# CITY OF ALBUQUERQUE

**Re: Chelwood Park Apartments, 1409 Chelwood Park,  
Request for Permanent C.O. –Accepted  
Engineer's Stamp dated: 01-16-12, (J22/D001)  
Certification dated: 09-10-12**

**Re: Chelwood Park Apartments Grading and Drainage Plan  
Engineer's Stamp date 01-16-12 (J22/D001)**

**Re: Chelwood Park Apartments Grading and Drainage Plan**  
**Engineer's Stamp date 12-28-11 (J22/D001)**

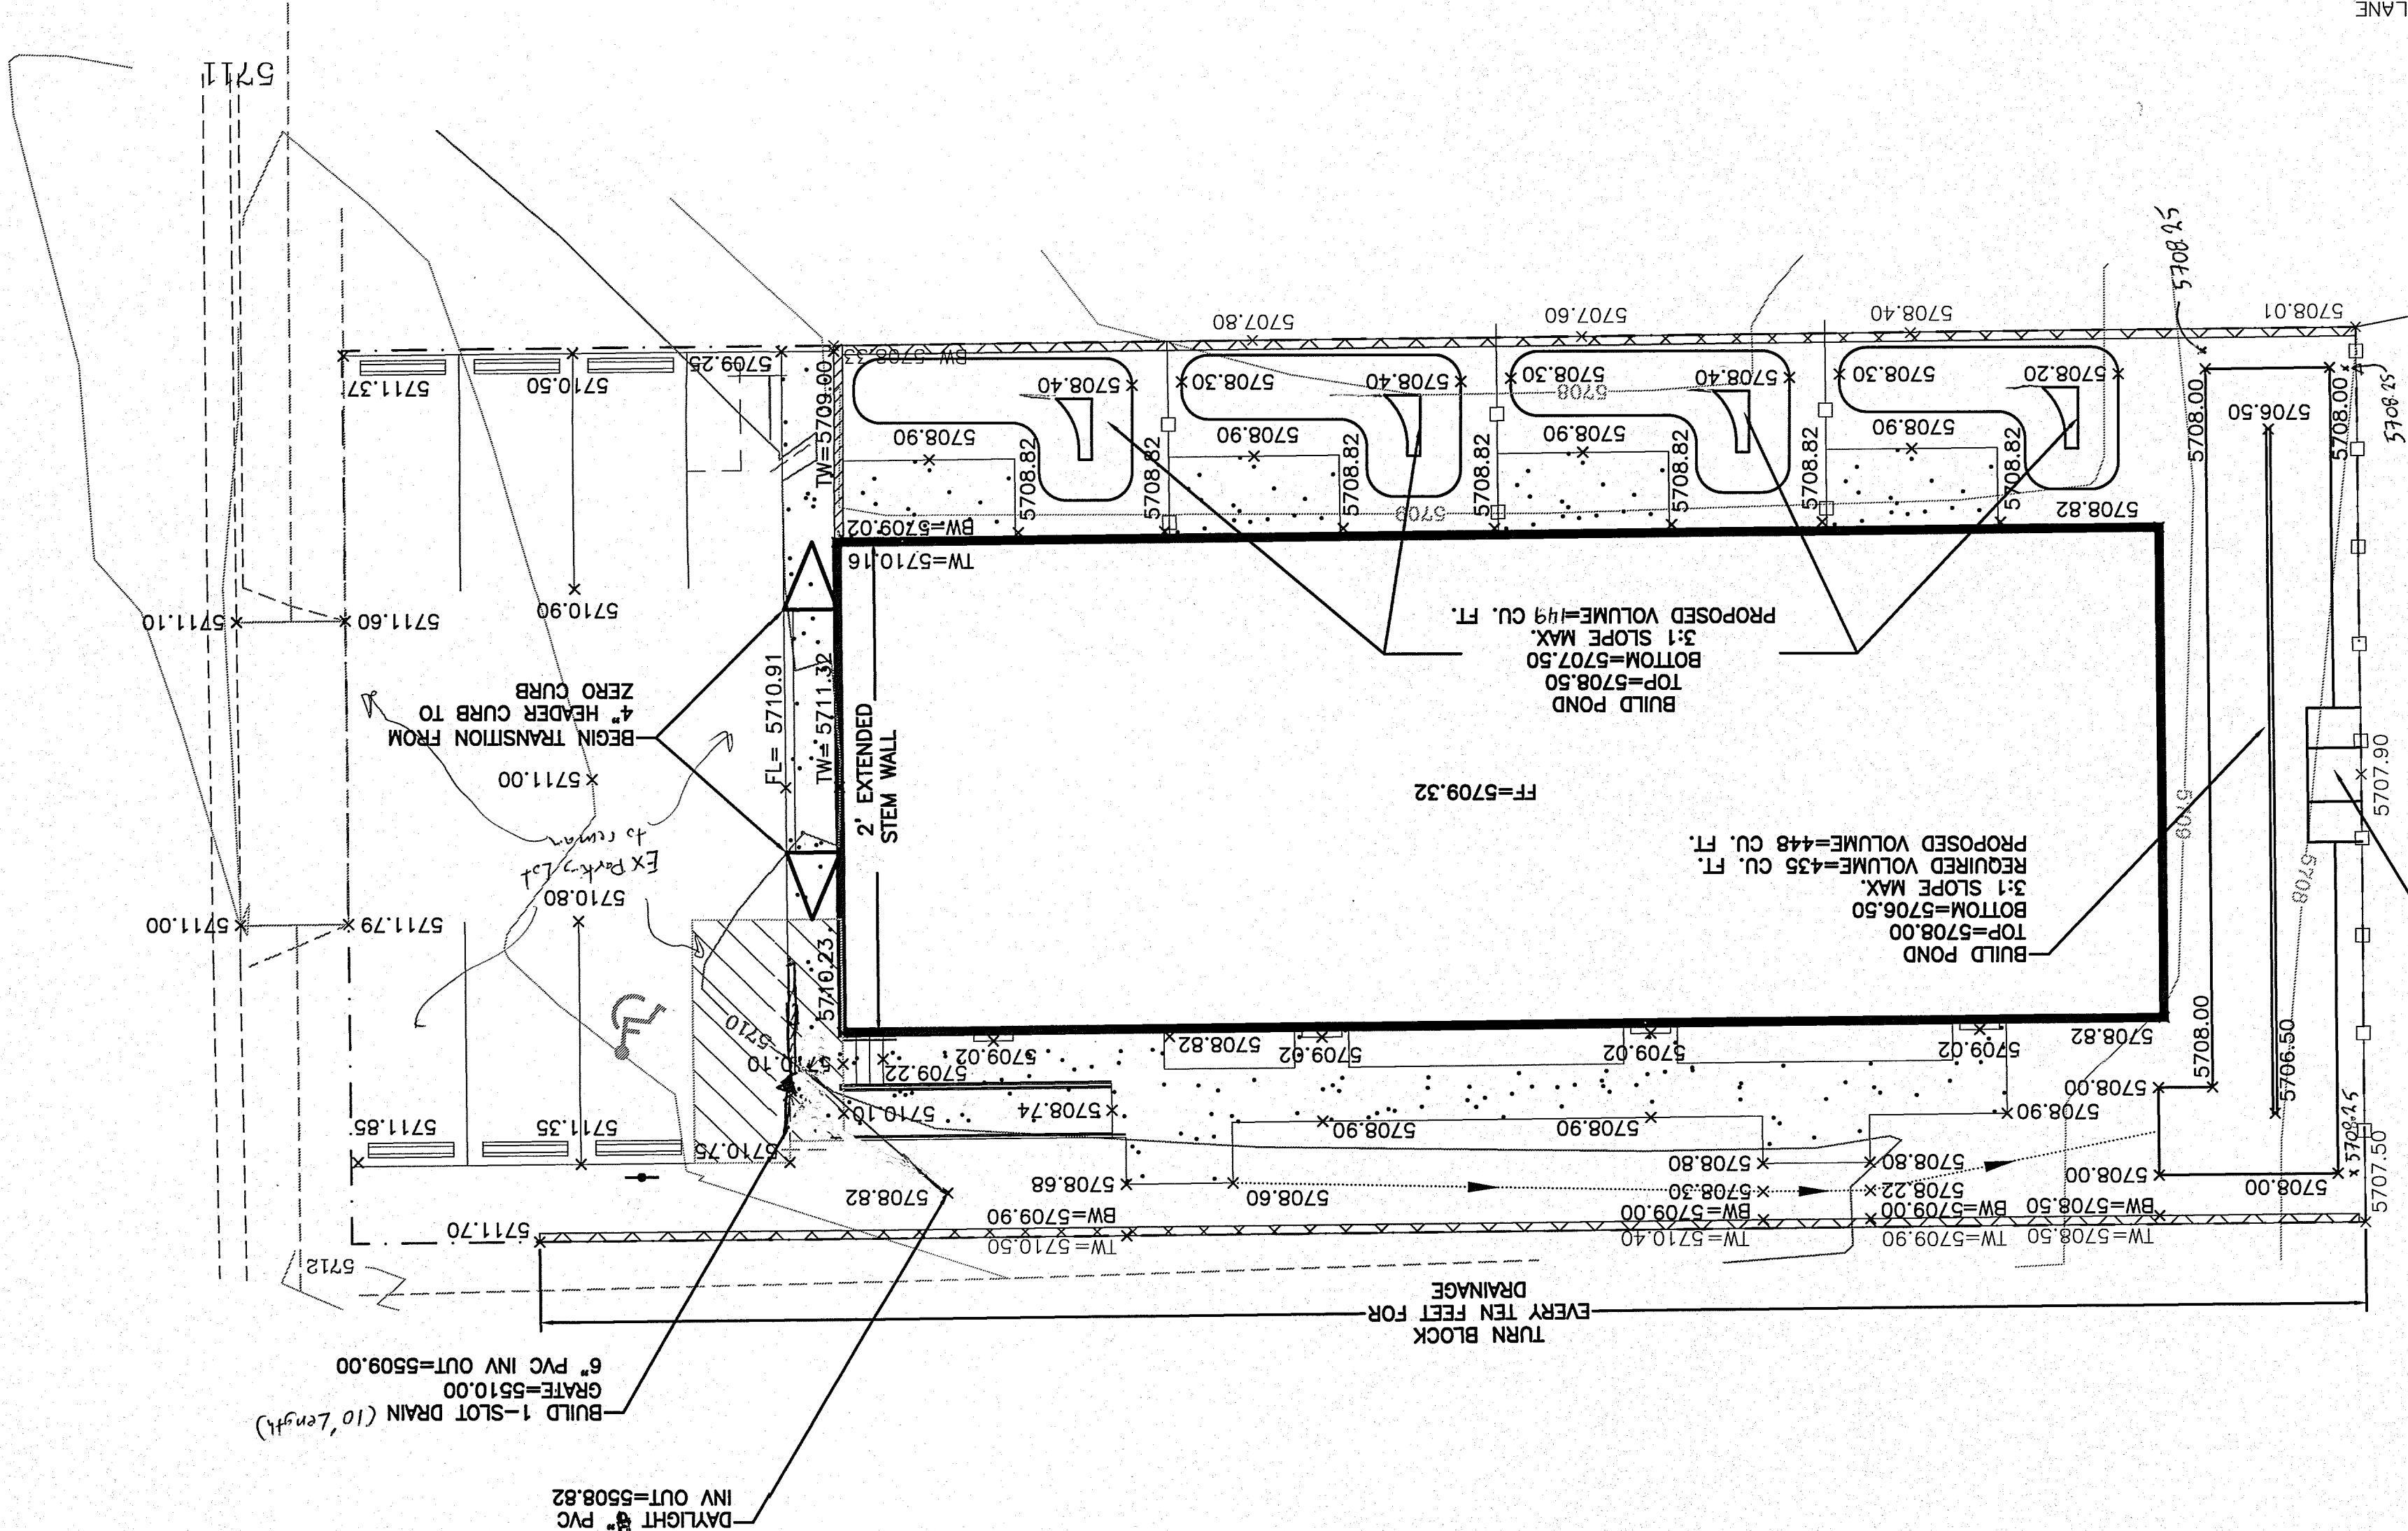
- Hydrology recommends that your rear yard ponds be graded to spill over towards the west into the larger pond once they have exceeded capacity.
- The emergency overflow in the larger western pond should then spill over towards the western property line.
- The proposed screen wall on the northern edge appears to redirect and concentrate existing flows at a point, is it possible to allow these flows to still penetrate the wall in a few locations?
- The drive entrance should include spot elevations along Chelwood Boulevard to ensure an adequate water block is provided.
- Are the spot elevations provided at the southern portion of the parking area intended to match existing grades?
- Provide additional spot elevations in the parking lot to ensure that the basins drain as intended.

1. Hydrology recommends rear yard ponds spill to the west. ✓  
**The plans changed so the ponds overflow to the west.**
2. Emergency overflow on large west pond should spill to west ✓

**The plans changed so the pond overflows to the west.**
3. Allow flows on north to enter site without concentrating. ✓  
**The plans changed such that the wall has turned blocks at grade to allow flow to enter site.**

4. The drive entrance shall include spot elevations. ✓  
**The site is the reconstruction of a burnt down home. The existing parking lot will not be altered the spots have been added but no improvements to parking lot to be done.**

5. Are spots provided in the southern portion of the parking lot intended to match existing grade. ✓  
**The spots are existing grades the parking remains as is.**

6. Provide additional spots in parking area ✓  
**The spots are existing grades the parking remains as is.**
